31 March 2022

## **HERITAGE RESPONSE TO SUBMISSIONS - INTERCONTINENTAL ALTERATIONS AND ADDITIONS SSD - 7693 - MOD 2**

SITE PLAN
 TITLE
 JOB NO 6680
 DWG NO 1001
 ISSUE A

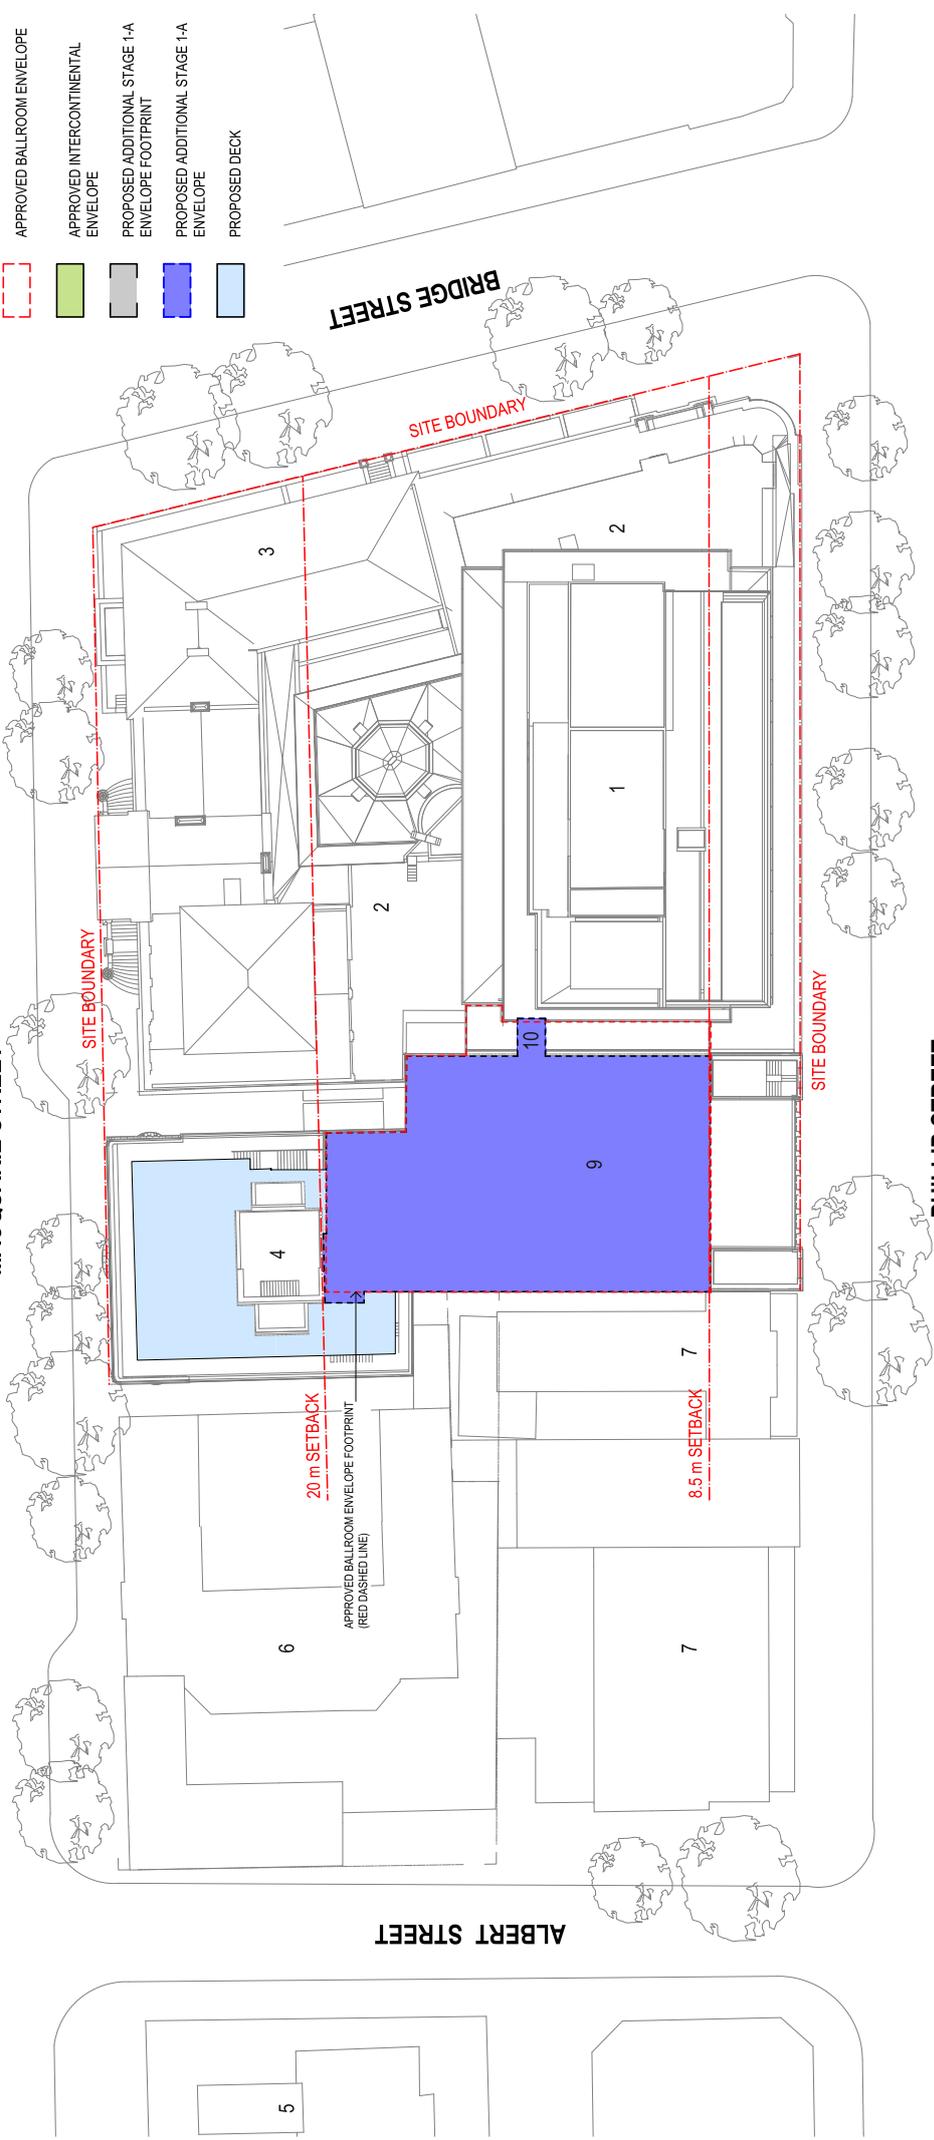
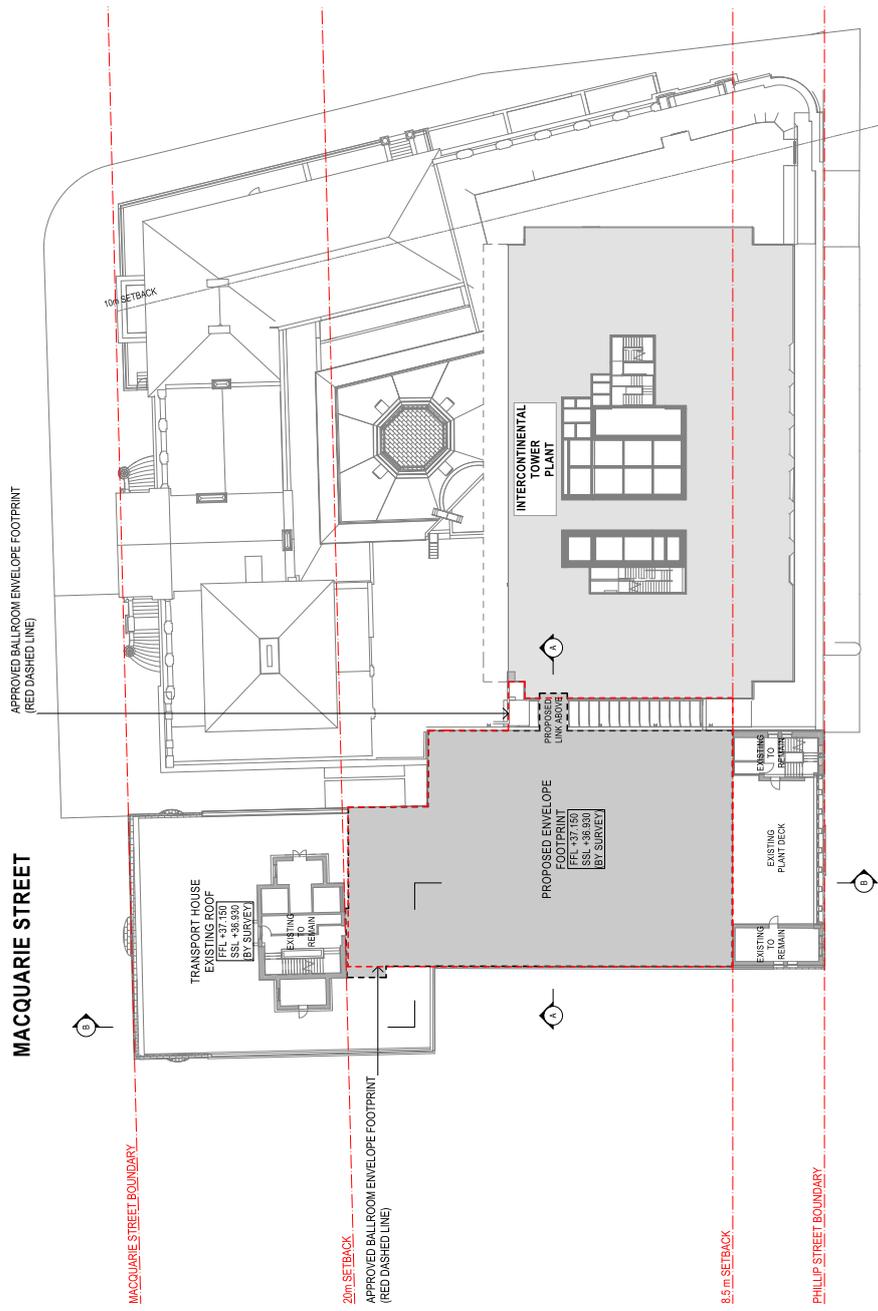
**The proposed deck, balustrade etc. were not part of the previous approval. The works are within the 20m setback imposed by the Independent Planning Commission and so may be in contravention of the previous approval. These works will have an adverse heritage impact in terms of view, setting and integrity. There is likelihood of further impact of associated works probable to follow, such as shade structures, lighting, seating, roof top landscaping, etc. In**

**view of the above, the proposed deck is not supported. The drawings do not indicate the setback of the glass balustrade from the existing parapet which needs to be clear.**

The proposed deck itself will not be visible behind the parapet so there is no potential for impacts on the setting or views as stated in the comment. The balustrade would be visible; however, it is a minor element which is likely to be glazed (this materiality can be agreed with HNSW) and which is intended to have a setback of approximately 2.9 metres from the parapet. The existing parapet would remain dominant in the streetscape. The balustrade would likely be difficult to view from the public domain on Macquarie Street and from further away would be so minor that it would not form a key focal points in views. A revised VIA can be provided during the detailed SSD process.

PROPOSED ADDITIONAL STAGE 1-A ENVELOPE: SECTION A

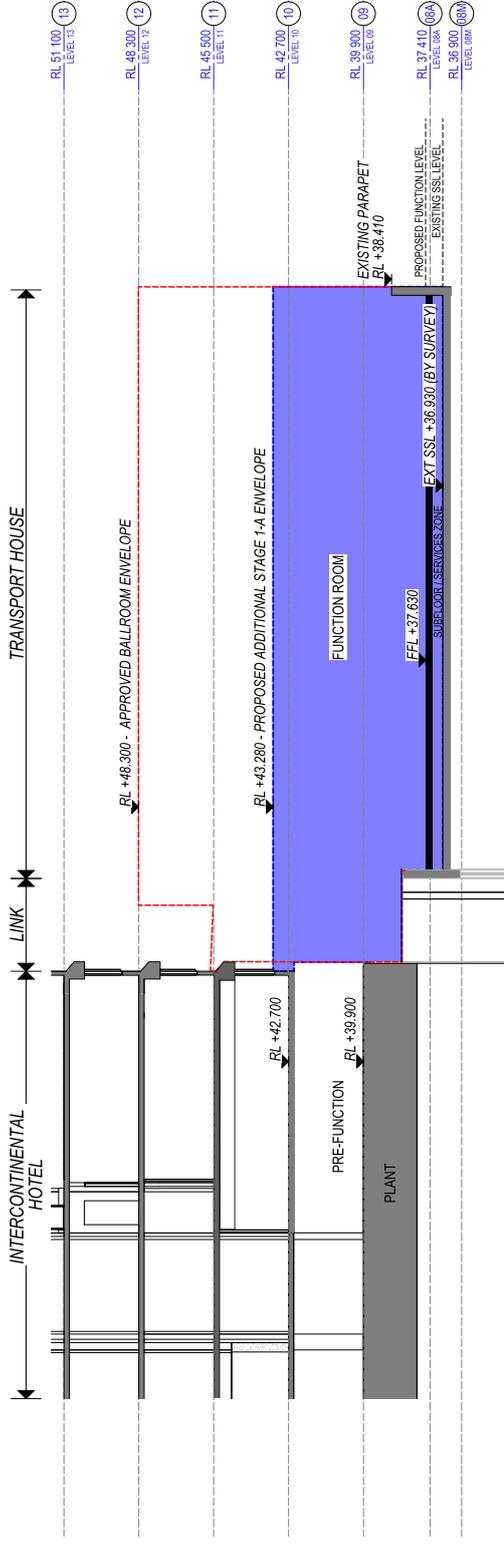
**The proposal describes the addition as a single storey even though the proposed height is 6.35m. It should be clarified whether the proposed envelope will comprise one or two floors.**

The physical addition does not form part of this application. The intention is that the proposed building envelope facilitates a single storey space, with a heightened ceiling appropriate to its use as a function space.
